75 York St.

City of Portland Site Plan Application

Date: May 12, 2003
Project name/number: 75 York Street, LLC, SSA #02034.00
Re: Building Permit Narrative
From: Scott Simons
To: City of Portland Planning Department
Cc: Paul Becker, Jobfile 3.1

75 York Street

SITE PLAN

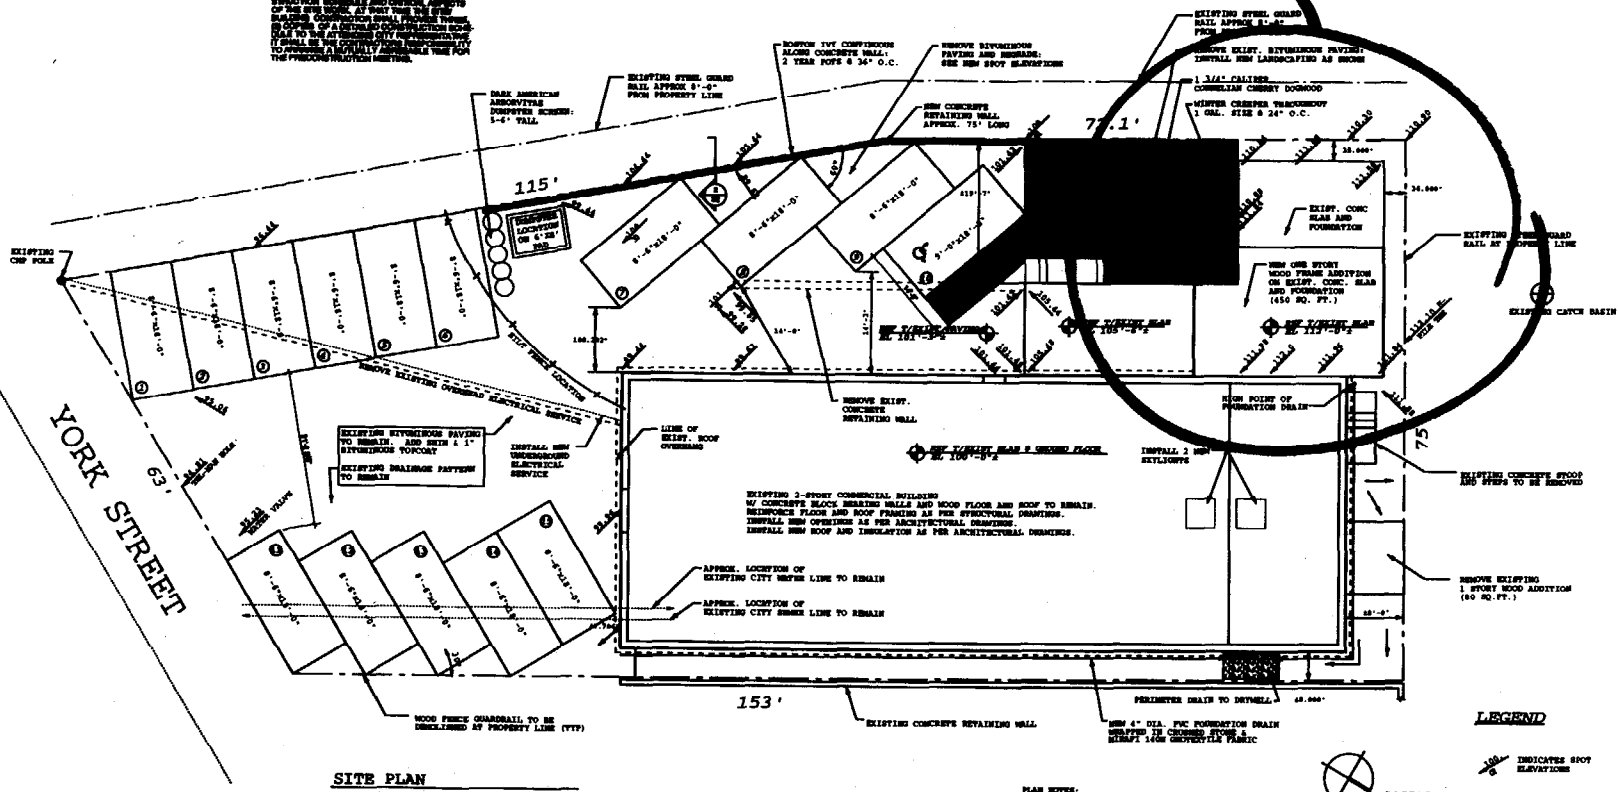
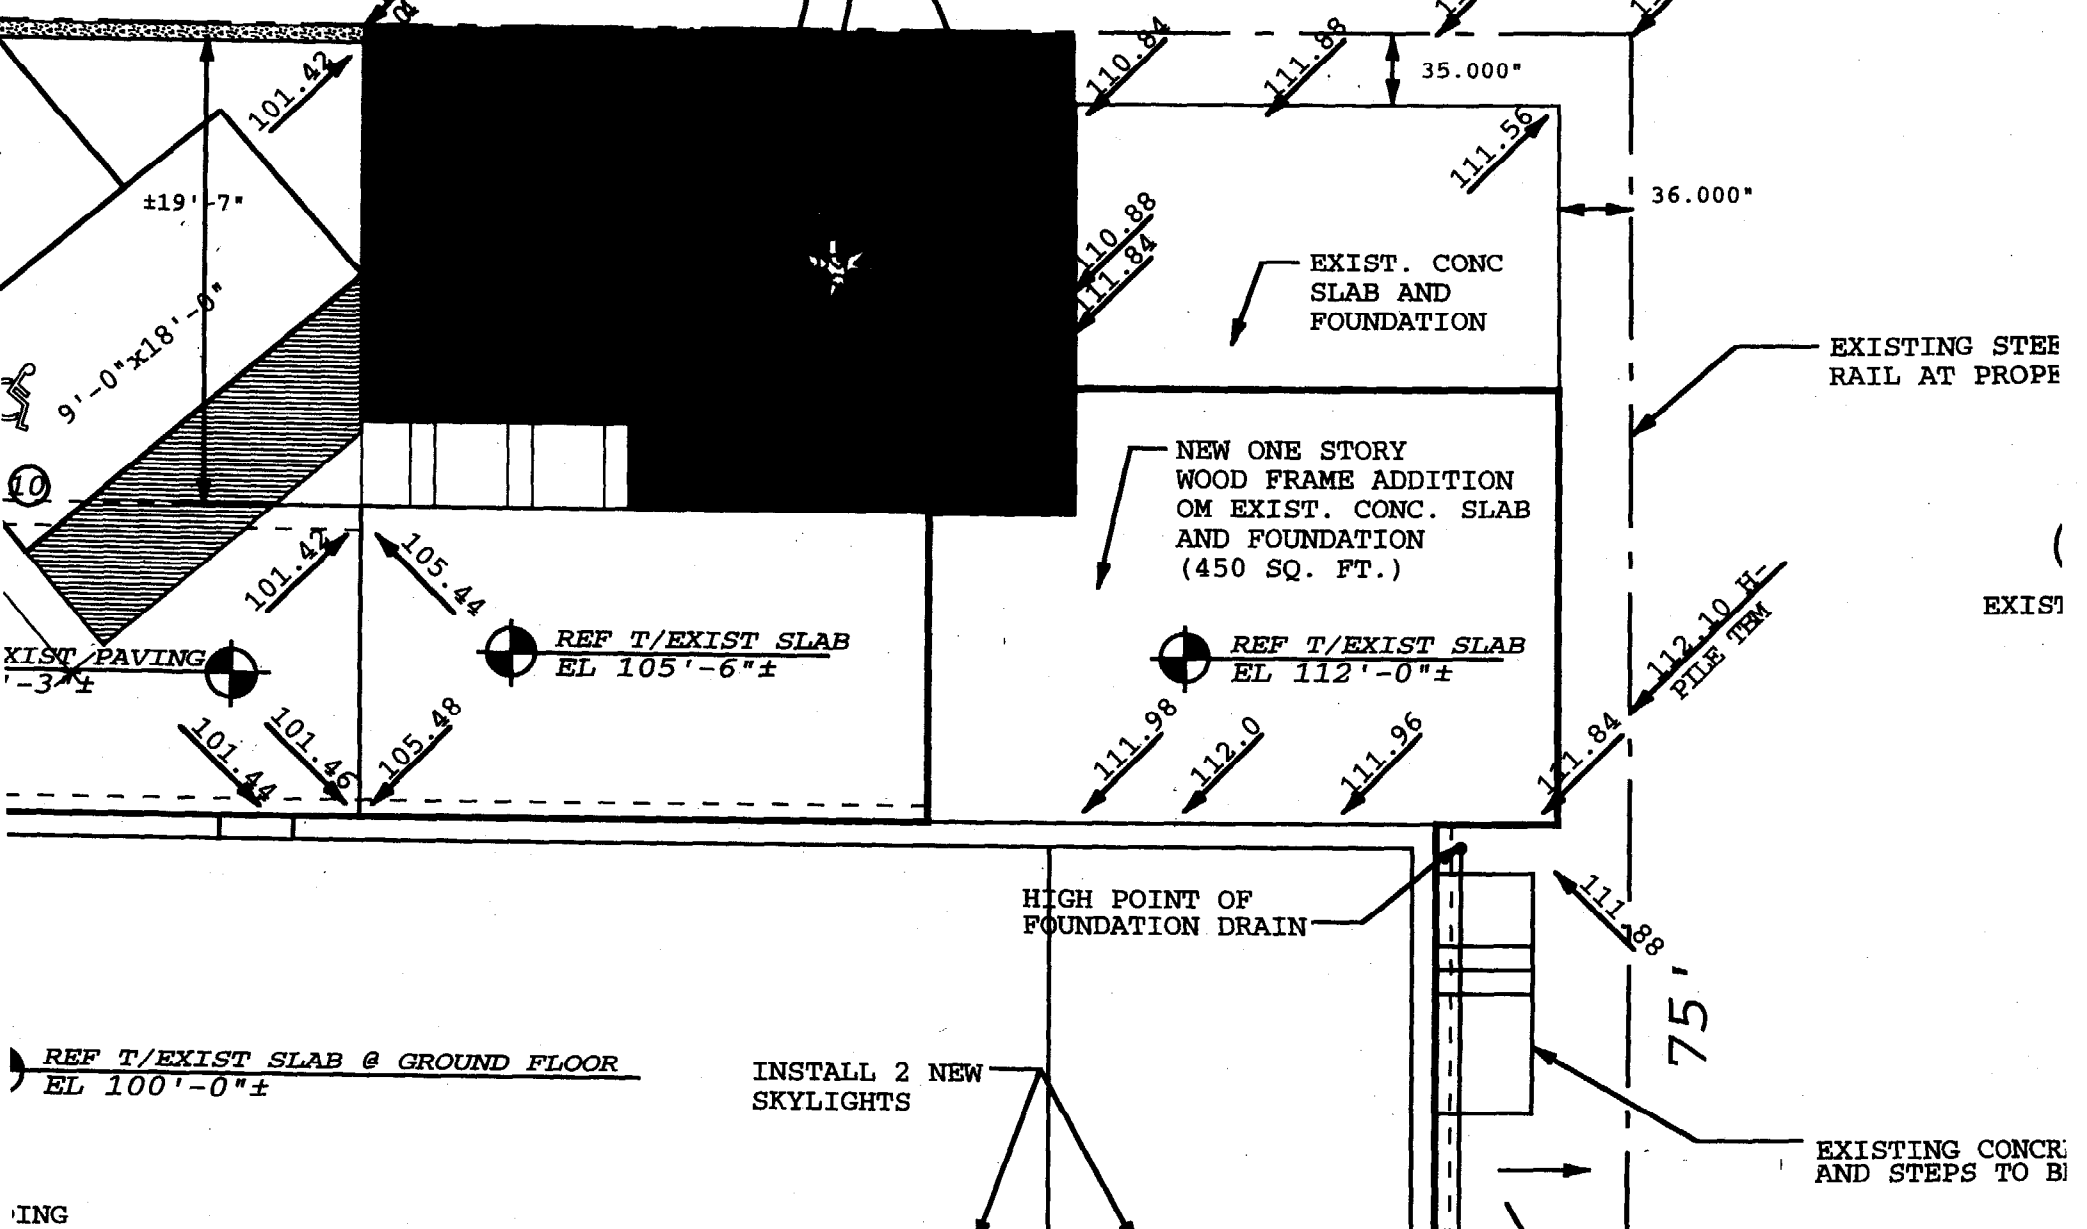
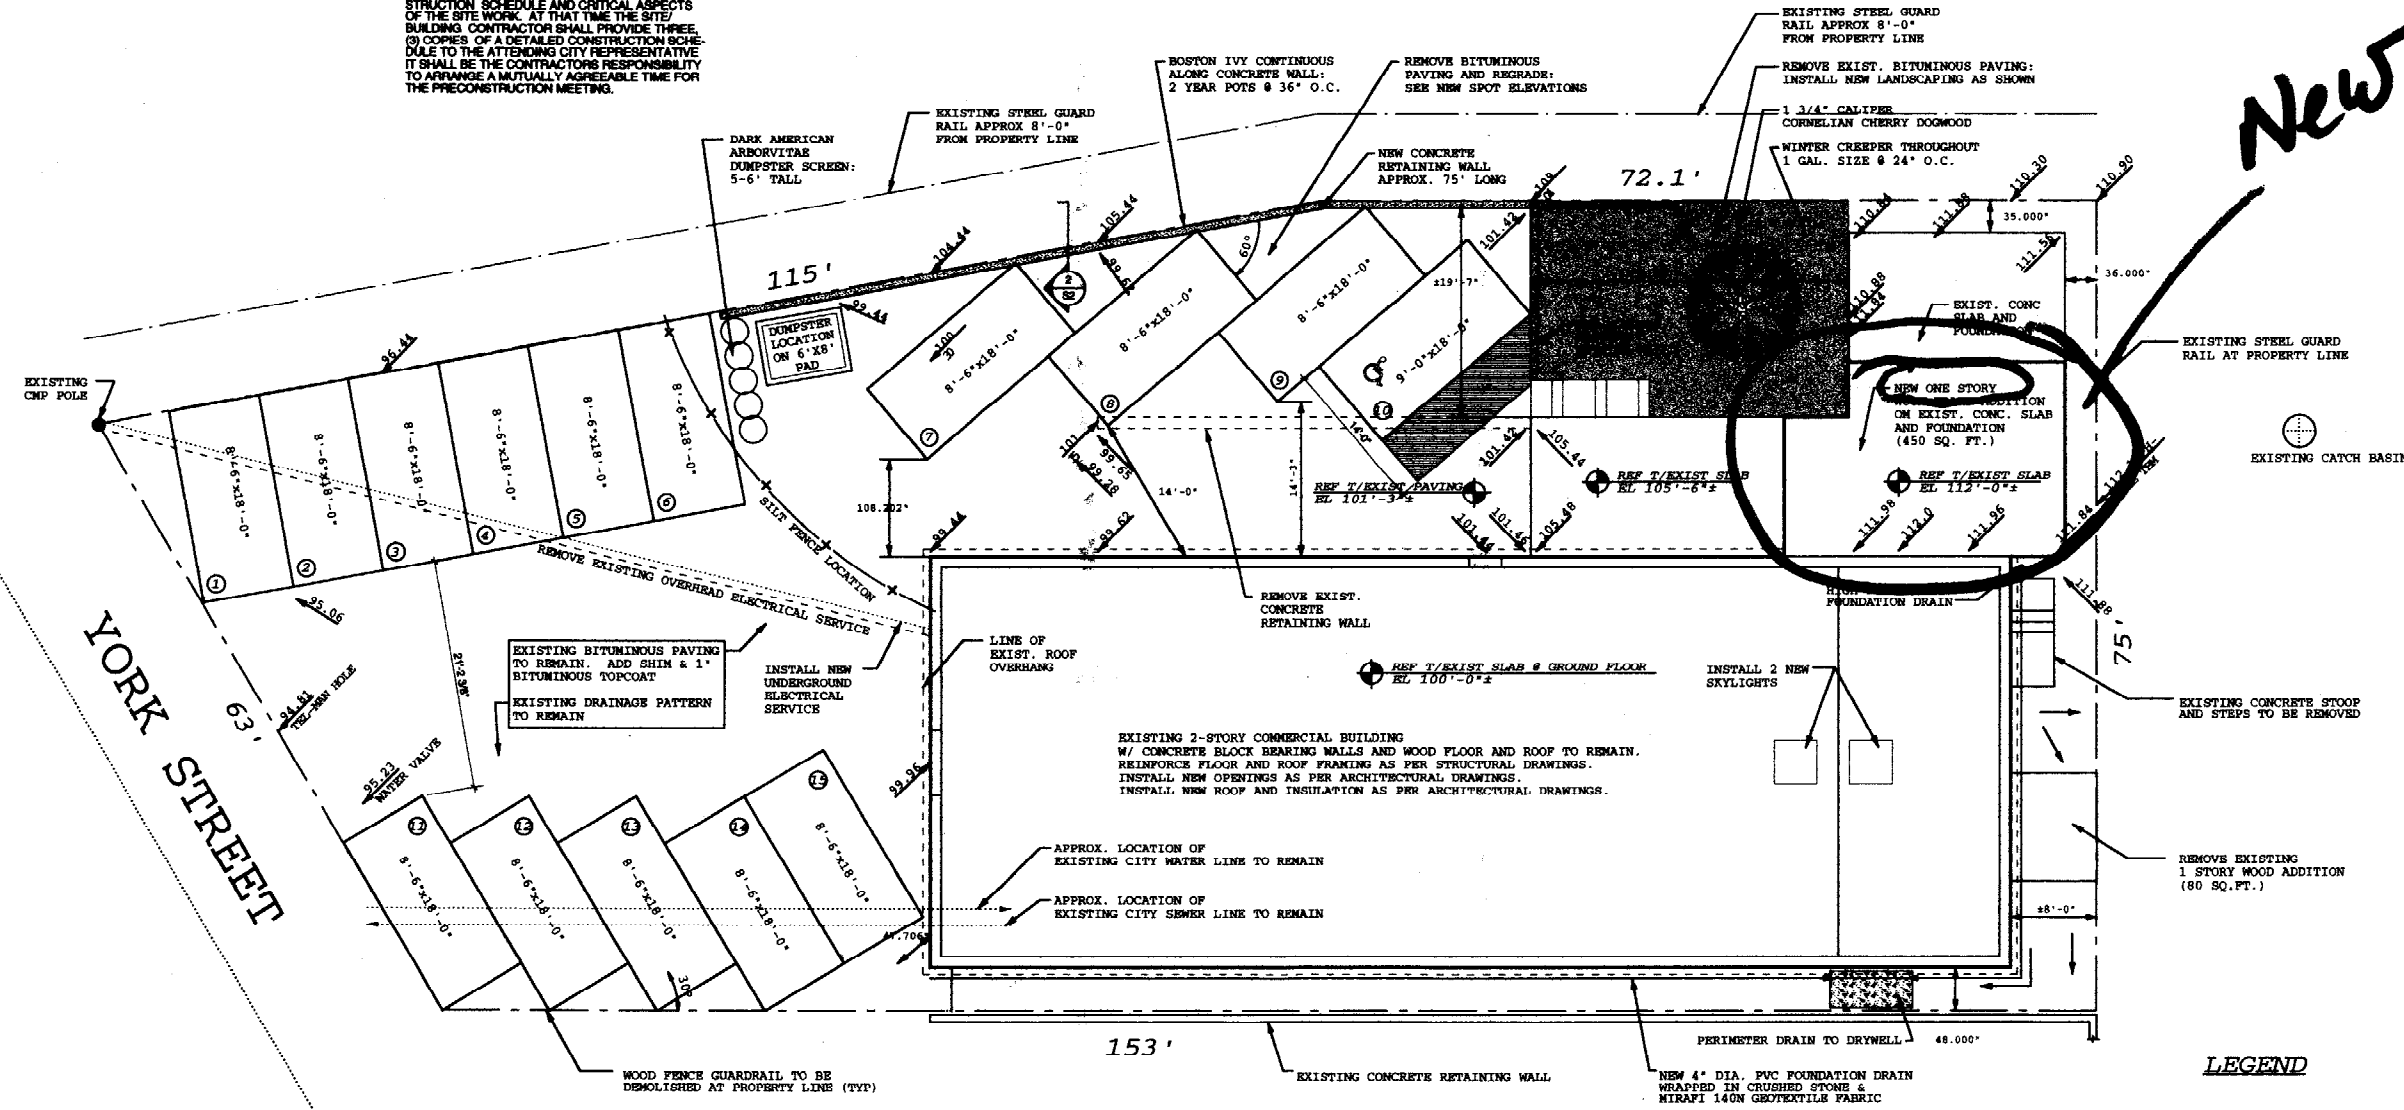
1. The submitted plan sheet, S1-"Site Plan", is quite deficient in delineating between proposed site improvements and existing conditions, particularly within the York Street right of way.

2. The plan specifies a 24 feet wide radial entrance. I am to assume this must be proposed. The existing entrance is approximately 40+ feet wide. In order to create this new entrance, the applicant must install radial granite curbing within the right of way. In addition, new brick sidewalk must be created to match into the existing brick sidewalk along the frontage.

3. The existing brick sidewalk along the property frontage is partially covered with pavement. Public Works is requesting the applicant remove the pavement covering the existing and rebuild the brick sidewalk as necessary. Further, the reveal on the existing granite curb, along the site frontage of York Street, is only 2 inches. Public Works is requesting the applicant reset the granite curb along the entire frontage of York Street to the appropriate reveal depth of 7 inches. The reset curb will need to appropriately match into the new curbing at the modified site entrance.

Hi Jay,
Just wanted to make sure you got the revised site plans yesterday for 75 York Street. Steve, from my office, worked out the details of the curbing and sidewalk directly with Tony Lombardo.
Please let me know if everything is in order. We are anxious to get started.
Thank you,
Scott Simons
